Summary of the attached document titled "GNRSBP Reg. [REDACTED] Communication to PINS," authored by John Gray (PINS ID [REDACTED]), dated 10 December 2025.

From: John Gray, PINS ID number [REDACTED], PINS Case Reference: EN010162  
To: Planning Inspectorate  
Date: 10 December 2025  
Subject: Recreation Changes in Bathley and North Muskham  
(Community Orchard, Permissive Footpath 3)

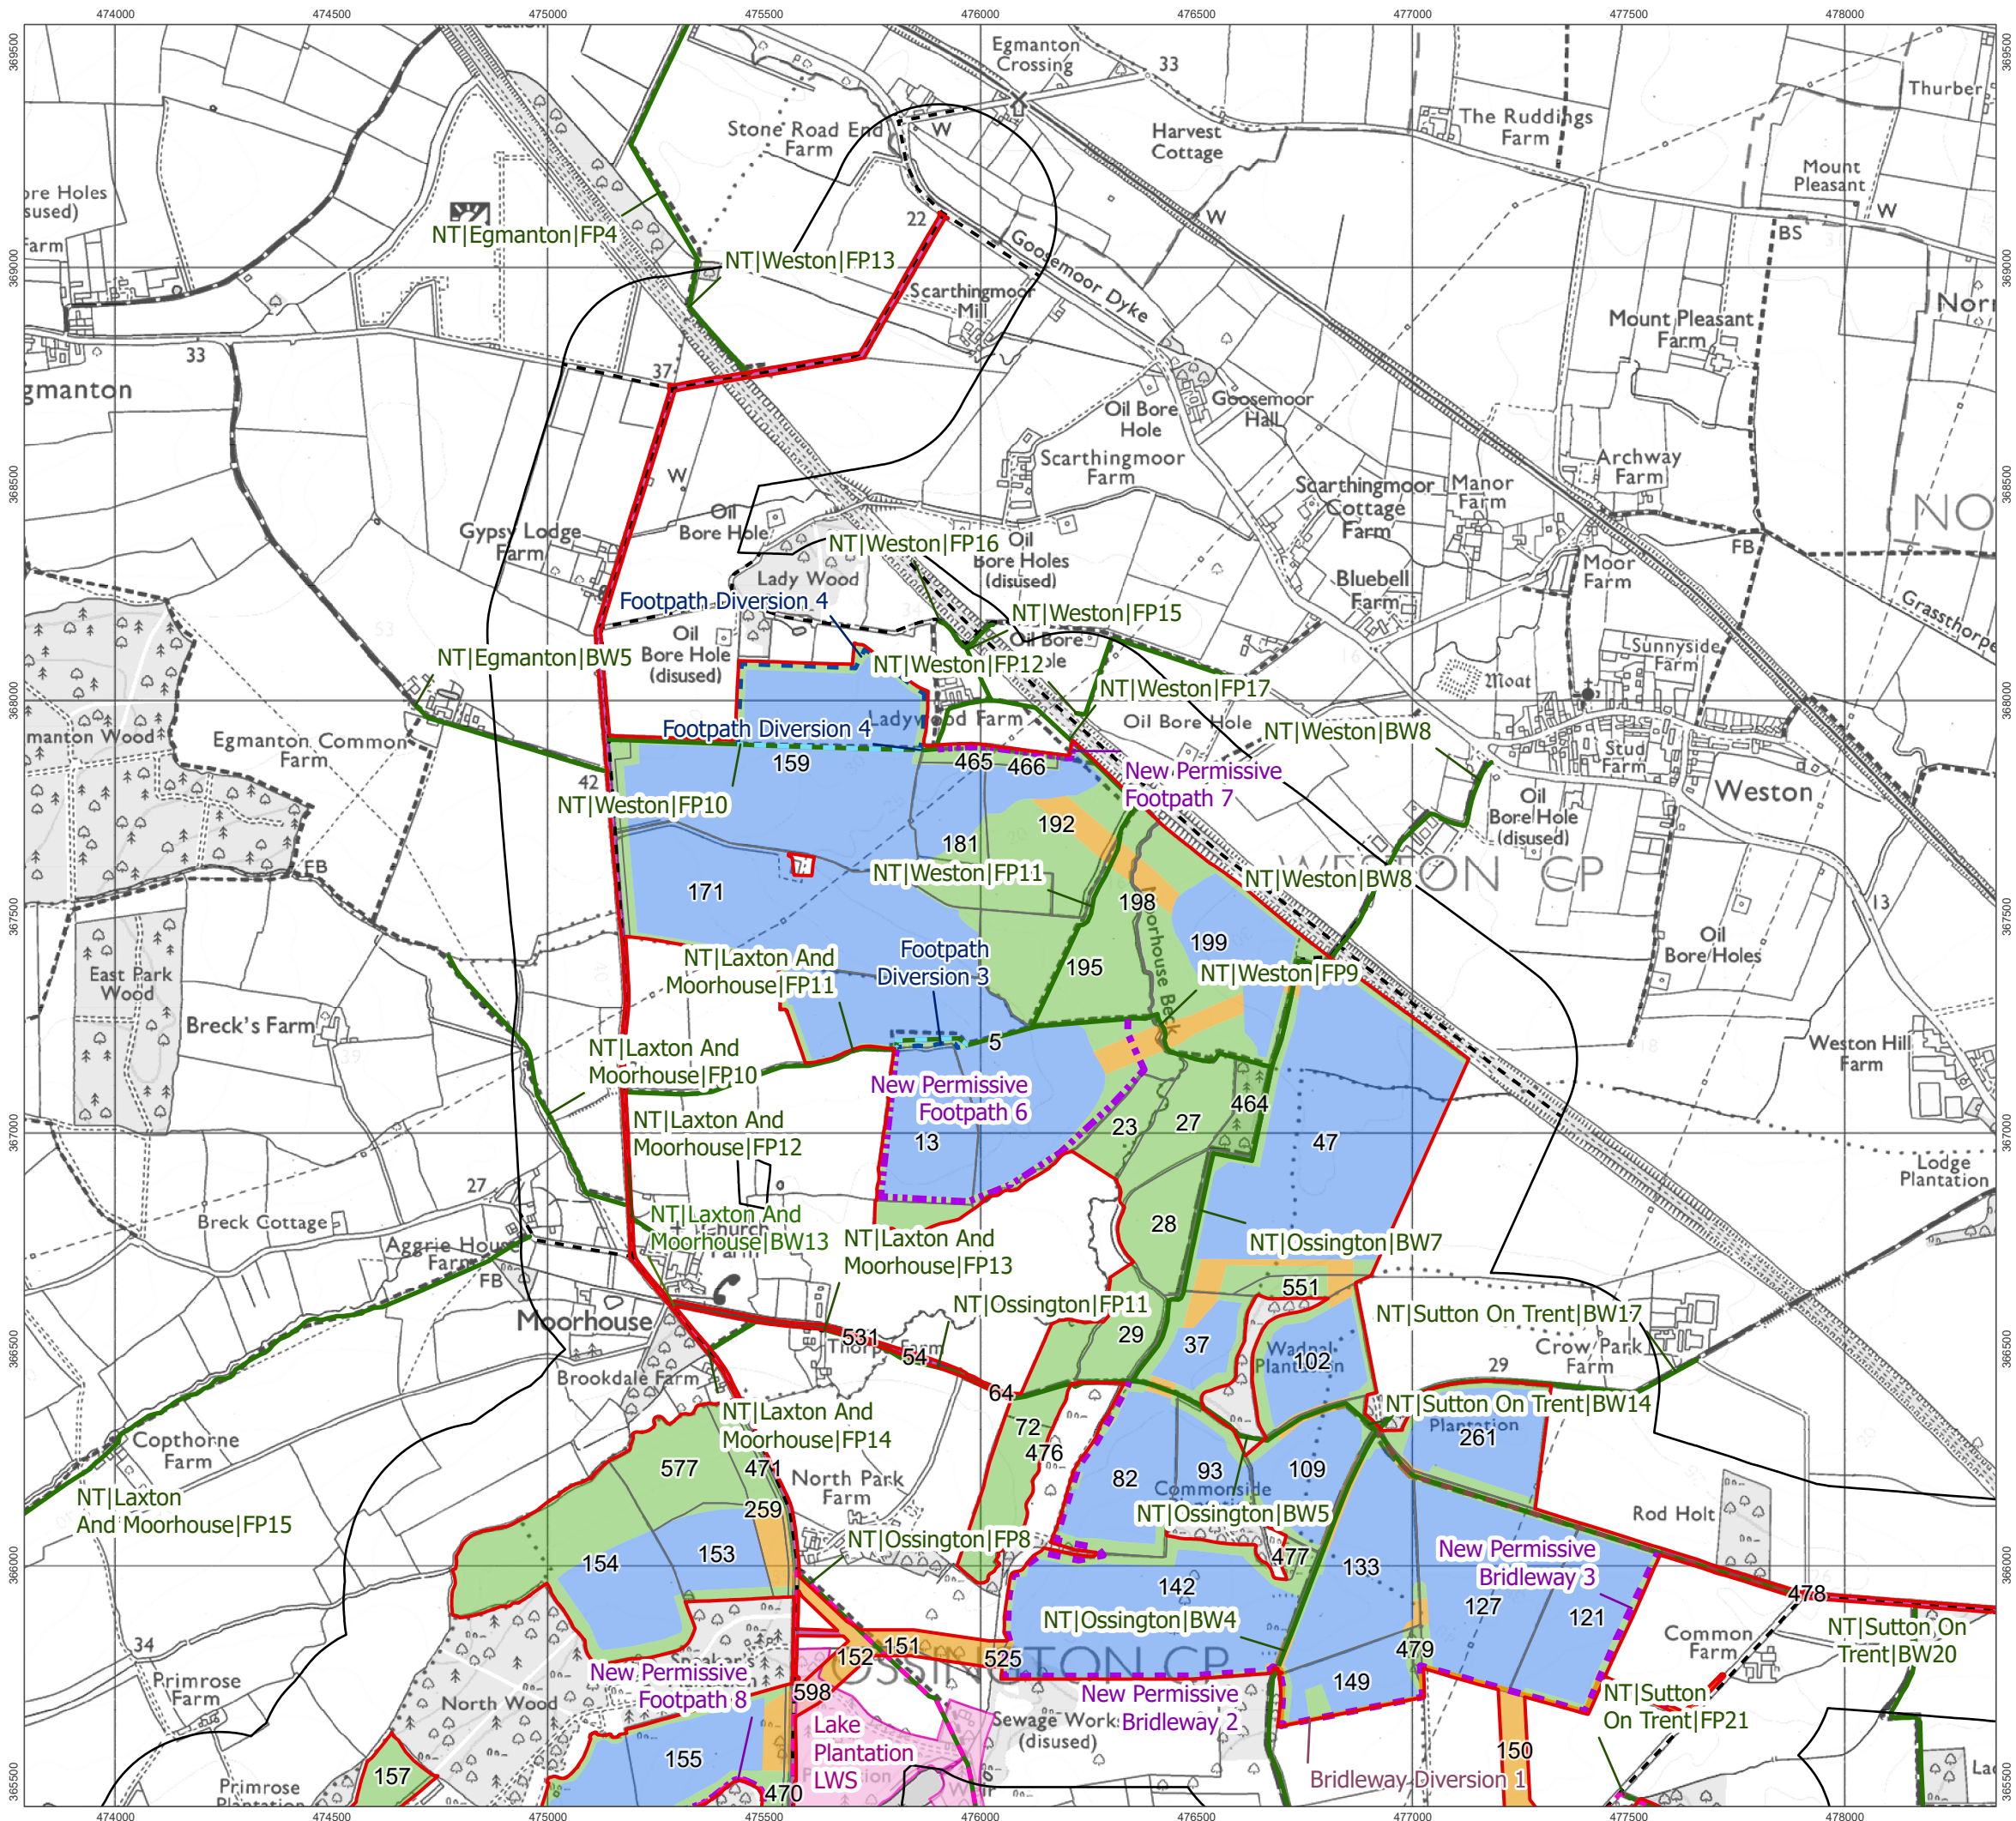
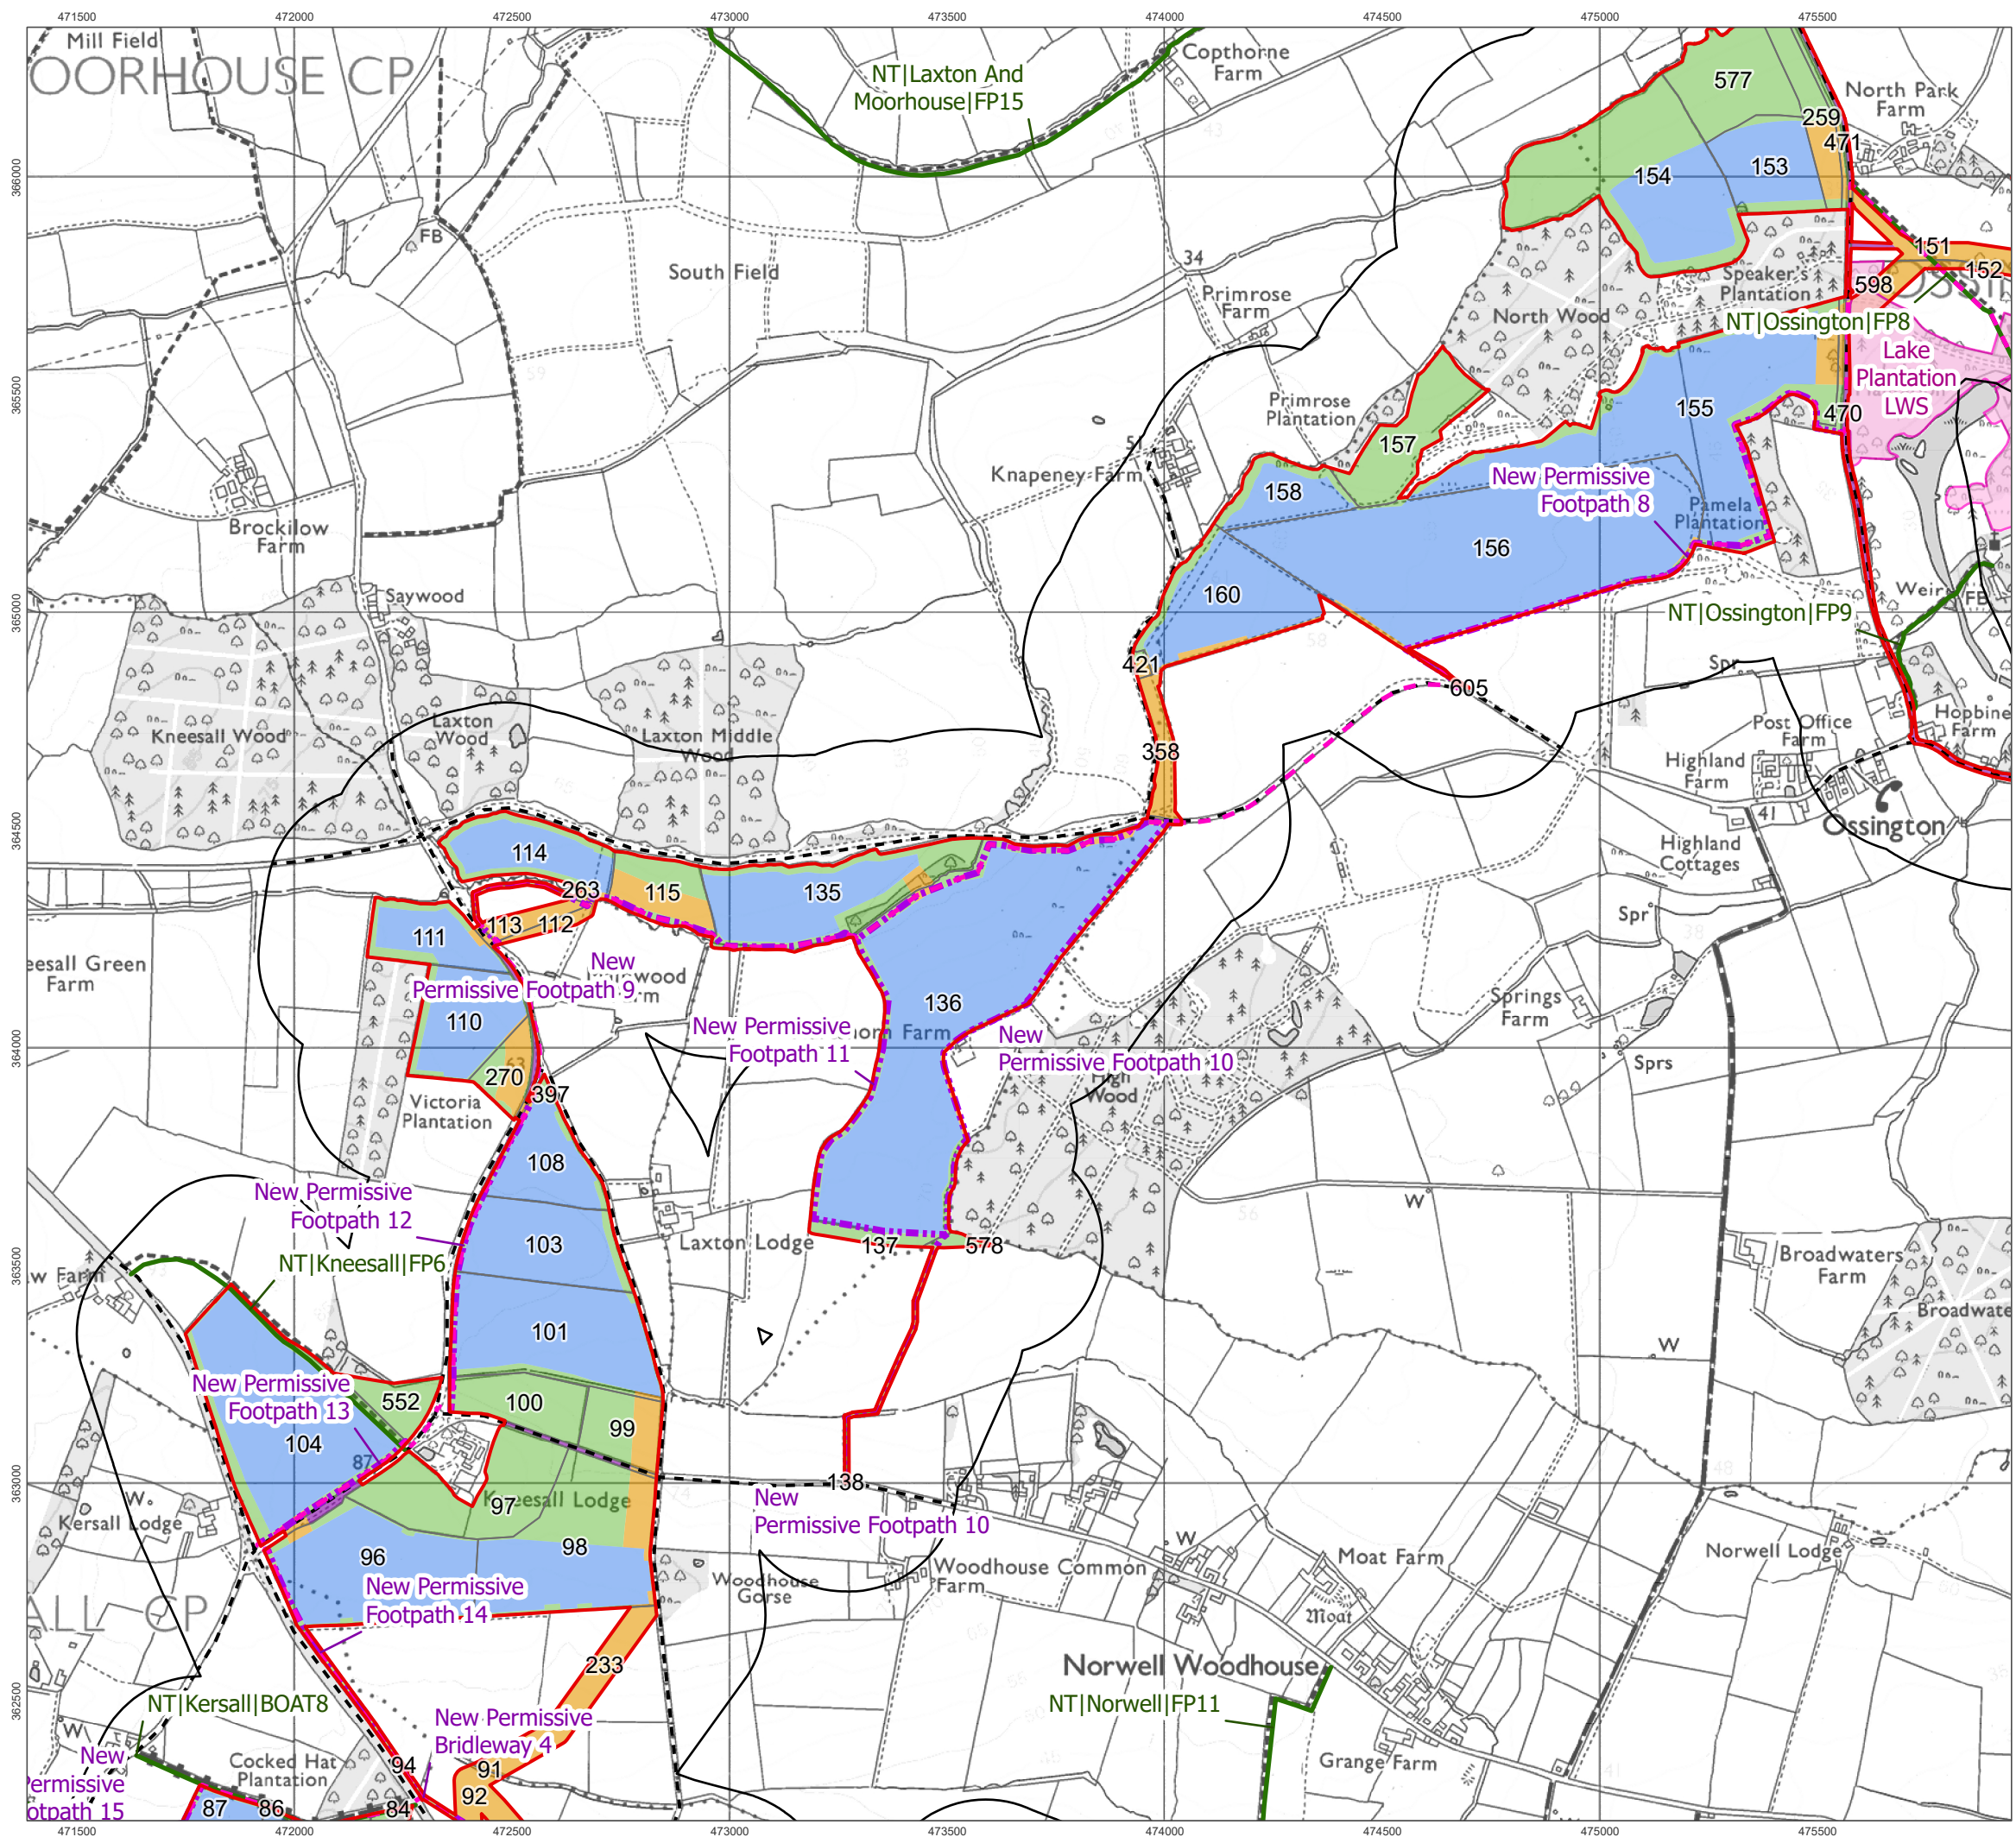
I write to ask that ExA consideration is given to issues arising from the two proposals labelled in Figure 1 Annotated extract of map from Elements Green's [APP-190,p.8] below.

Realigning the currently proposed PF3 route between B and C via point C+ would provide a minimum separation of 25m between PF3 and the pond; use an established (and dry) field track B-C+, and then follow a 60m new path along the southern edge of a minor dyke to rejoin the route at C.

***On the basis of several recent discussions with the resident I am persuaded that this realignment of Permissive Footpath 3 would protect the resident's conservation activities (and actually improve the route by avoiding the frequently very wet area immediately N of the pond).***
